Mrs Wendy Hardwell
116
Nyetimber Lane
Aldwick
PO21 3HL

Please ask for: Ms Iqraa Malik
Email: iqraa.malik@terraquest.co.uk
Telephone: 01212341390
Our Ref: AW/170/20/HH
Your Ref:
Date: 23rd July 2020

Application for Planning Permission for Works or Extension to a Dwelling

Development: Drop kerb
Location: 116 Nyetimber Lane Aldwick PO21 3HL

Block Plan shows area bounded by: 489971.95, 98709.96 490061.95, 98799.96 (at a scale of 1:500), OSGridRef: SZ90019875. The representation of a road, track or path is no evidence of a right of way. The representation of features as lines is no evidence of a property boundary.

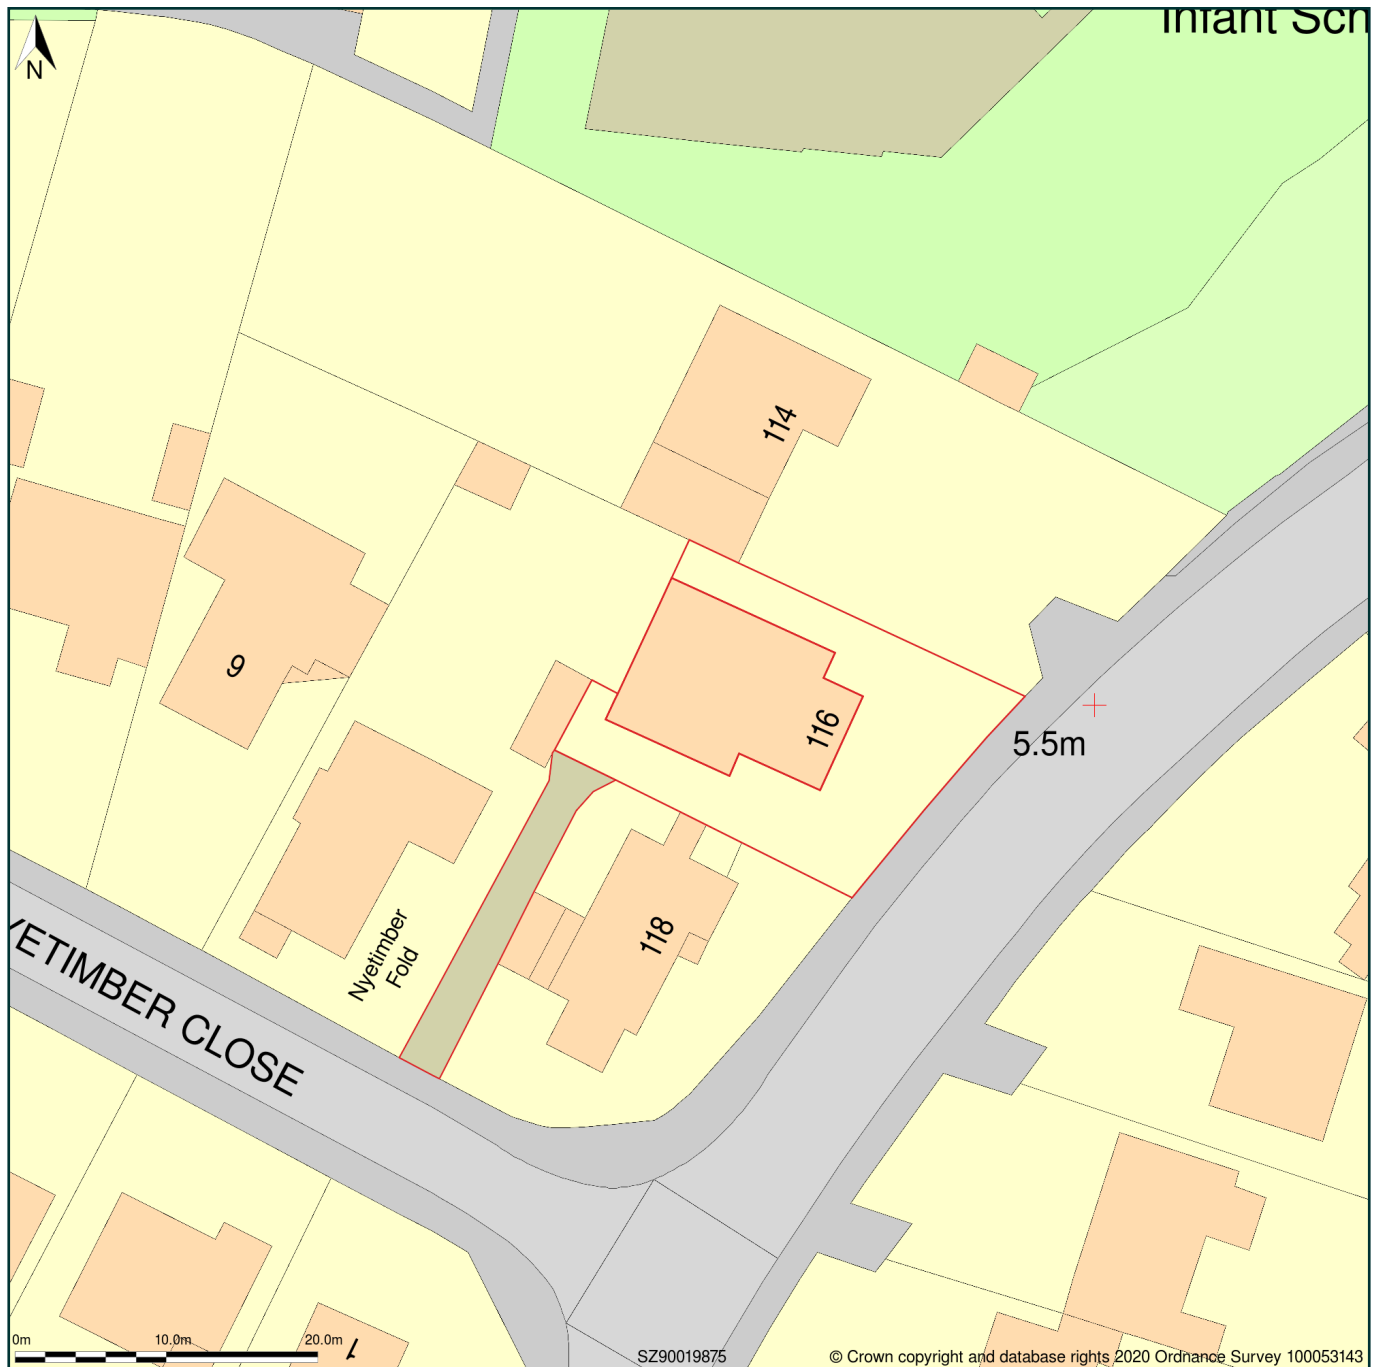
Block Plan

The scale bar and the visibility splays displayed on the block plan don't measure to scale. Please amend.
